City of Portland, Maine - Building or Use Permit Application
 389 Congress Street, 04101 Tel: (207) 874-8703, Fax: (207) 874-8716

| Permit No: 08-1092 | Issue Date: | CBL: 311 A012001 |

| Location of Construction: 31 WALDRON WAY | Owner Name: DAC LLC | Owner Address: 31 WALDRON WAY | Phone: |

| Proposed Project Description: Free Standing 6' x 88" Sign | | Signature: | | Signature: |

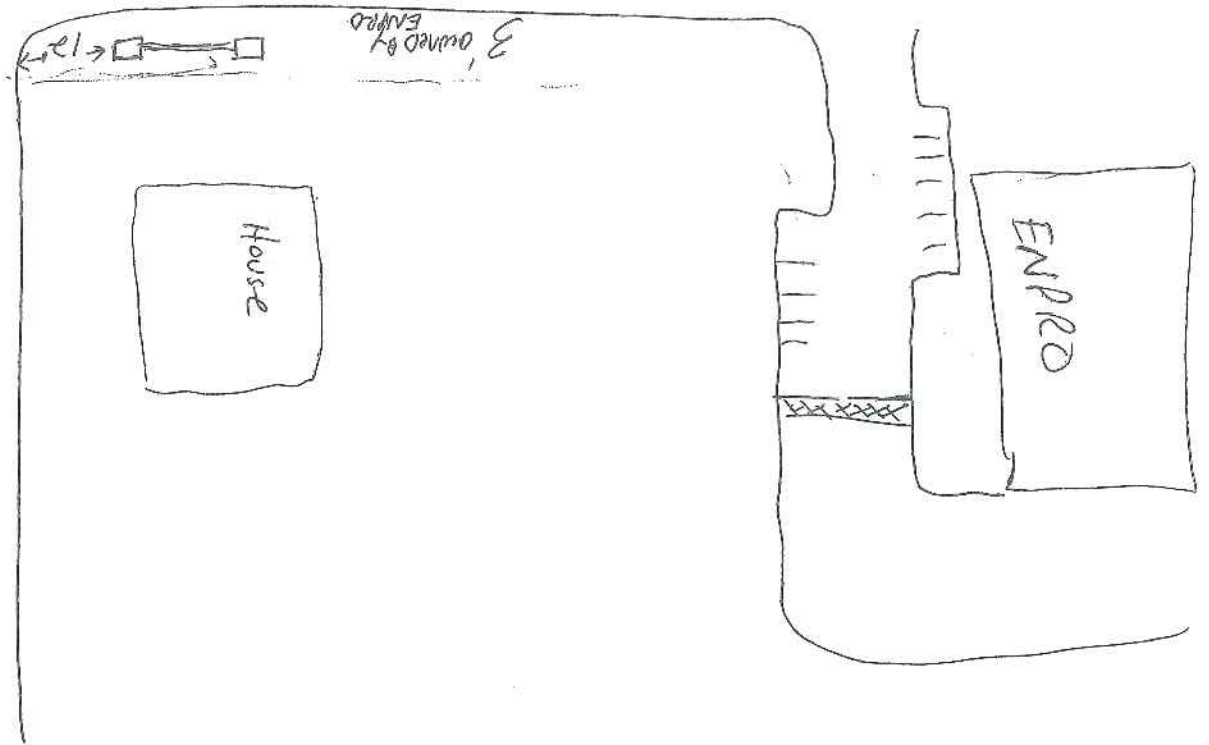
Note: The proposed placement of the sign (5' off the side property line) puts the sign in the right of way. Section 14-368(e) does not allow signs in the public right of way except for certain types. The proposed sign does not meet any of these criteria, so it can't be approved by zoning. Will give permit to planning under section 14-368.5(g). **Ok to Issue:**

Listened to the tape from the Planning Board hearing from 2/27/07 on 1/23/09. The application to locate the sign on Enpro's property within 5' of Mr. Skinner's property was denied because the applicant did not show that it met the standards of 14-526(23). There was some discussion about whether the sign could go on the other side (one or two board members explored the option), but there was no formal recommendation. Mr. Skinner's main concern was that the proposed sign was located too close to a gas line/tub. His concern was that if the sign was hit it could impact the gas line/tub. He had no objection to it on his side of the street as long as it was further from the gas tub.

- 1) The exception for the proposed sign at 31 Waldron review is approved with the condition that it be located as shown on the October 6, 2009 plan and maintains a 5 foot separation from the adjoining residential property.
